Planning Application Ref: AL/29/20/PL

Location: Tyrone House, Norton Lane, Norton, Aldingbourne, PO20 3NH

Description of works: Demolition of existing house & outbuildings & erection of 1no. new, detached, two storeys, 5-bedroom dwelling & detached garage. N.B. Previously approved scheme for various extensions to the existing property (ref. AL/105/19/HH).

-  Widened entrance to site
-  Proposed new dwelling
-  Proposed new outbuilding (garage)
-  As permitted AL/105/19/HH

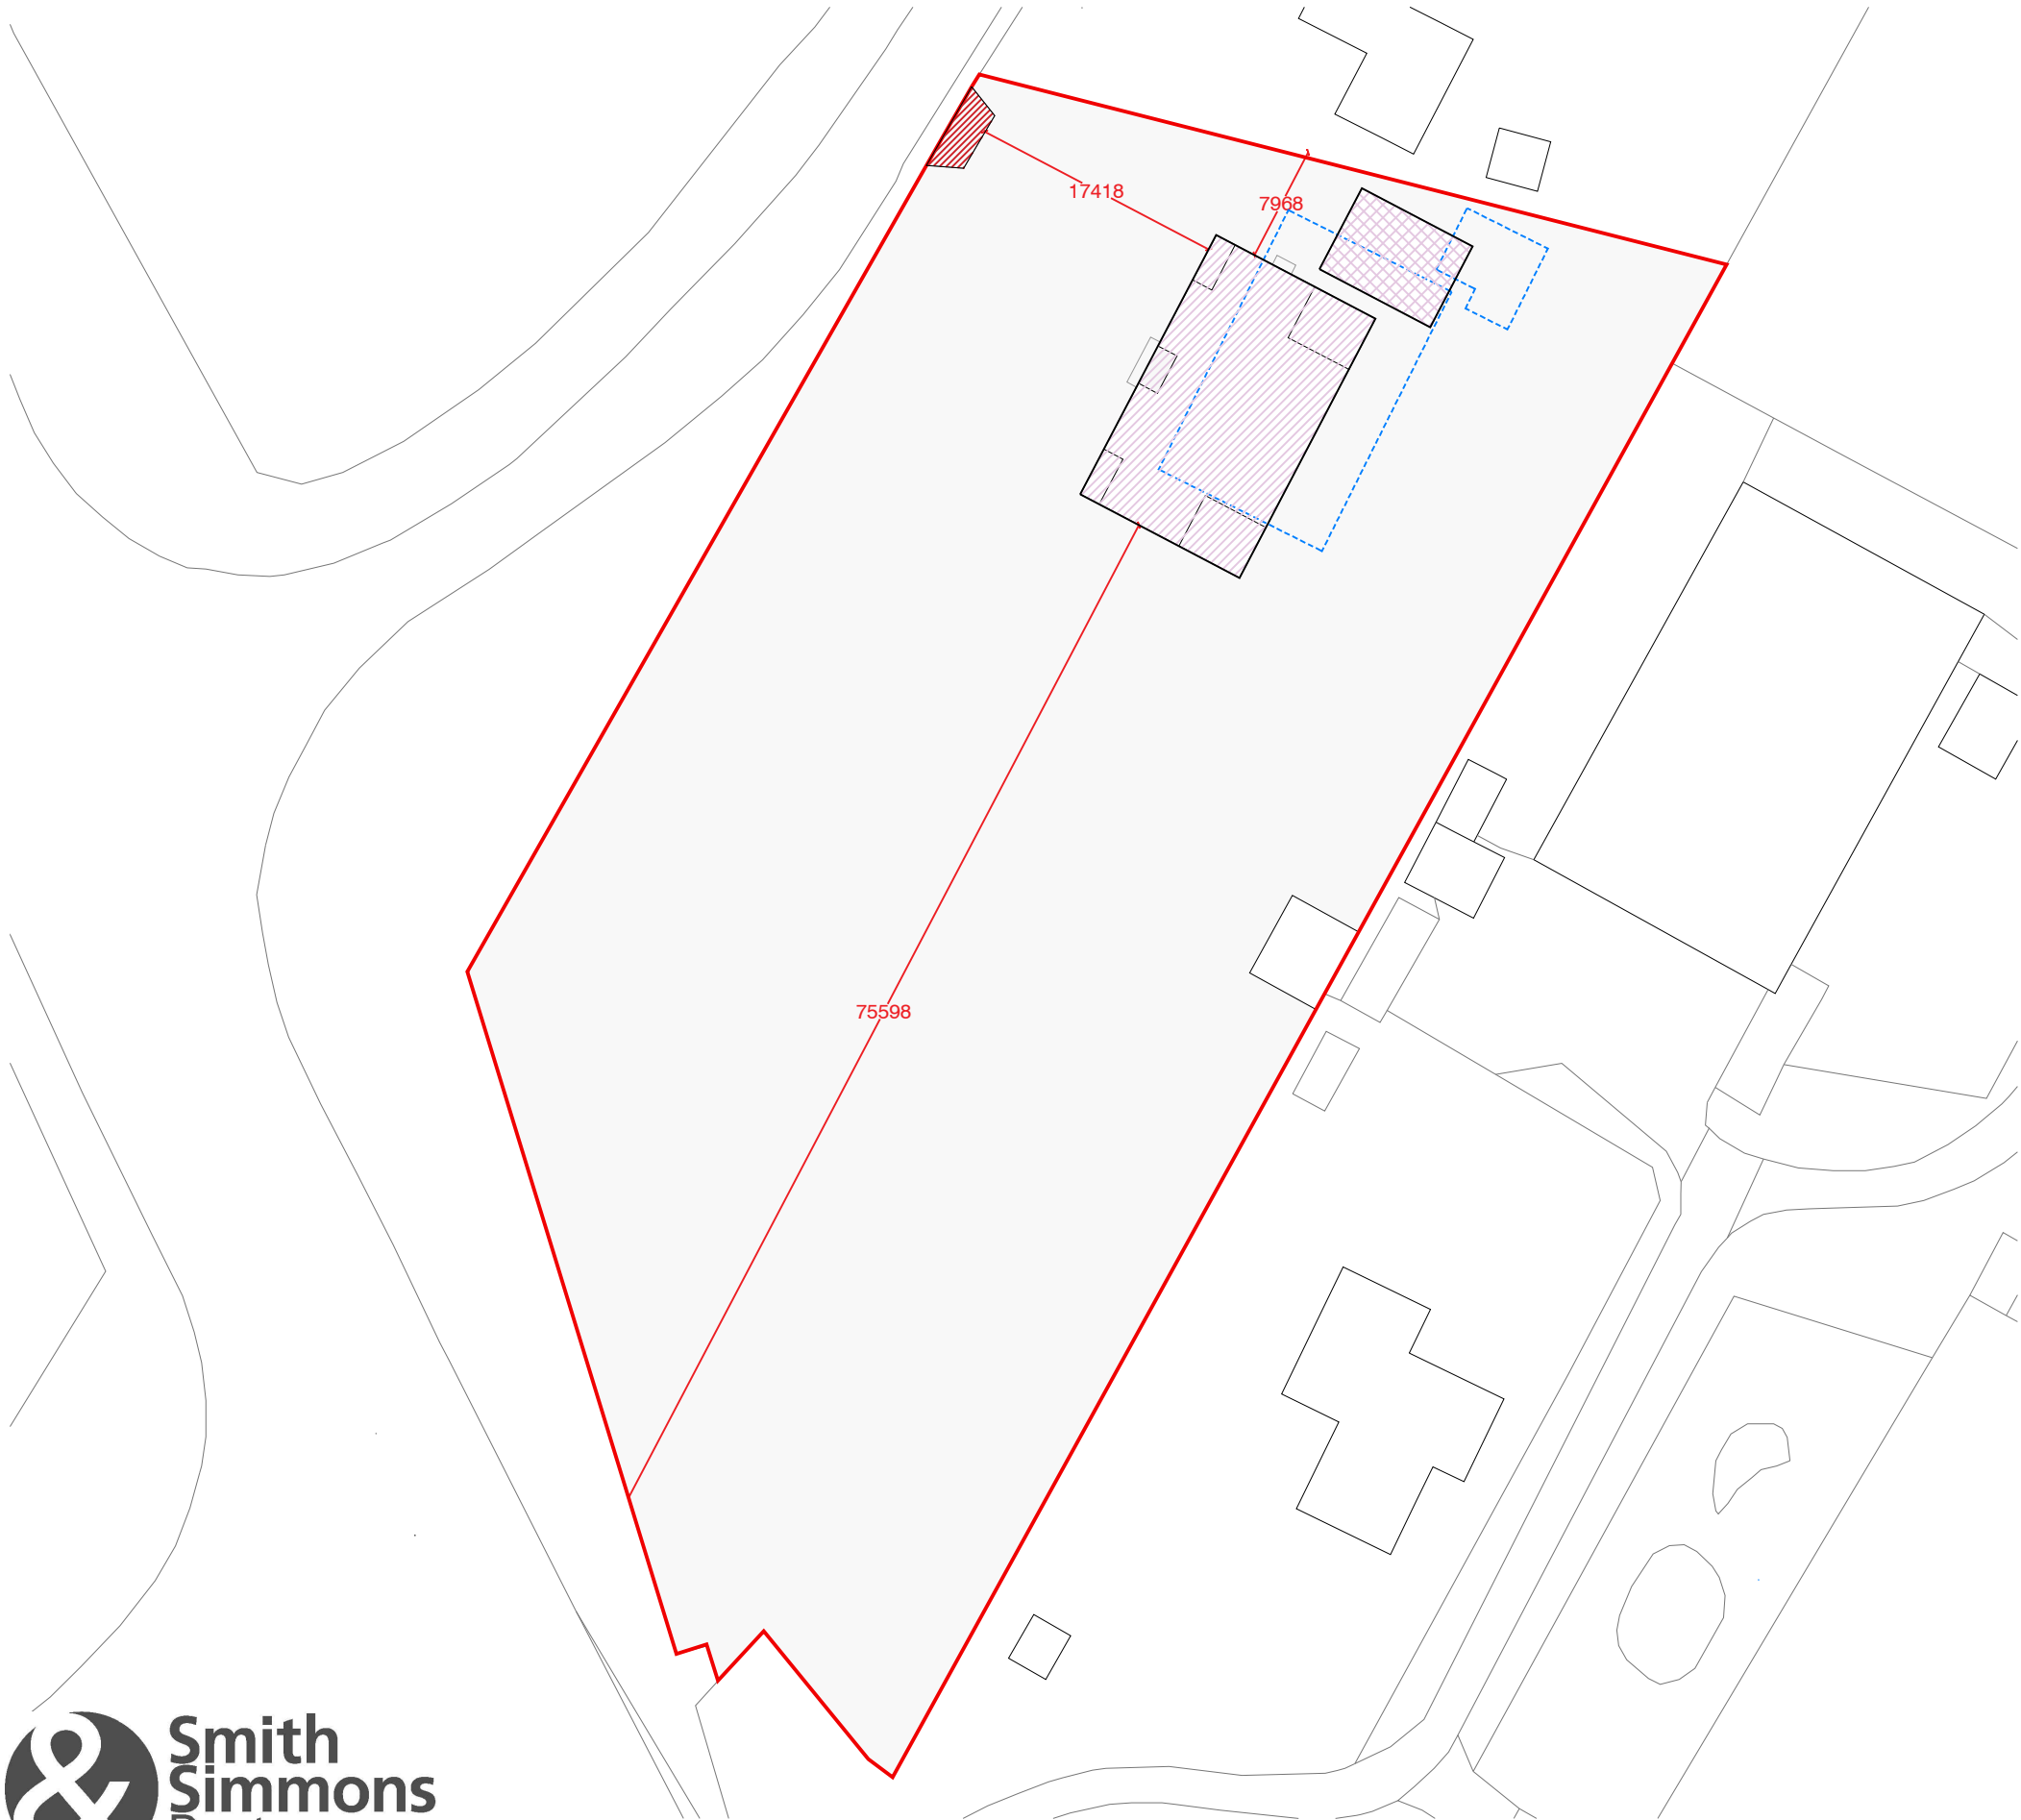
- The Tree Survey data provides an indication of the existing tree stock but is incomplete and does not accord with the requirements of BS5837:2012 – ‘Trees in relation to design, demolition and construction’.

- There are significant on-site trees, some of which may be worthy of statutory protection and could be adversely affected by these proposals. There is no supporting information from an Arboricultural Expert submitted with the application - a requirement of BS5837:2012. As such, were this application to now proceed, we will not have sufficient information to guarantee such trees would be adequately respected and protected.

- At first glance, the following information is absent from the submissions received so far – that is required if we are to be reassured that the ongoing health and vitality of retained trees will be safeguarded:

- Tree category ratings
 - Root protection area schedule
 - Tree retention and removal plan
 - Tree protection fencing and ground protection - specifications.

- Method of demolition (existing dwelling)
 - Construction Management Plan (storage of materials, delivery area, etc.)
 - Supervisor(?) of work within RPA of retained trees.

- Driveway and service installations within RPA of retained trees – methodology described and easements observed?

1. The applicants will need to employ the services of an Arboricultural Consultant to carry out a tree survey exercise and then prepare an Arboricultural Impact Assessment (AIA) which must be inclusive of; a ‘Tree Survey Schedule’, a ‘Root Protection Area (RPA) Schedule’ and a ‘Tree Constraints Plan’ – with the trees accurately plotted on same.
2. In the event that a RPA of any tree which is proposed for retention overlaps the development then BS5837:2012 requires that the Detailed Planning Application is accompanied by an Arboricultural Method Statement (AMS) and also most importantly a Tree Protection Plan – to both describe and illustrate the mitigation measures which are to be employed to ensure that the trees survive without detriment to their vigour and vitality and are given adequate protection both above and below ground.
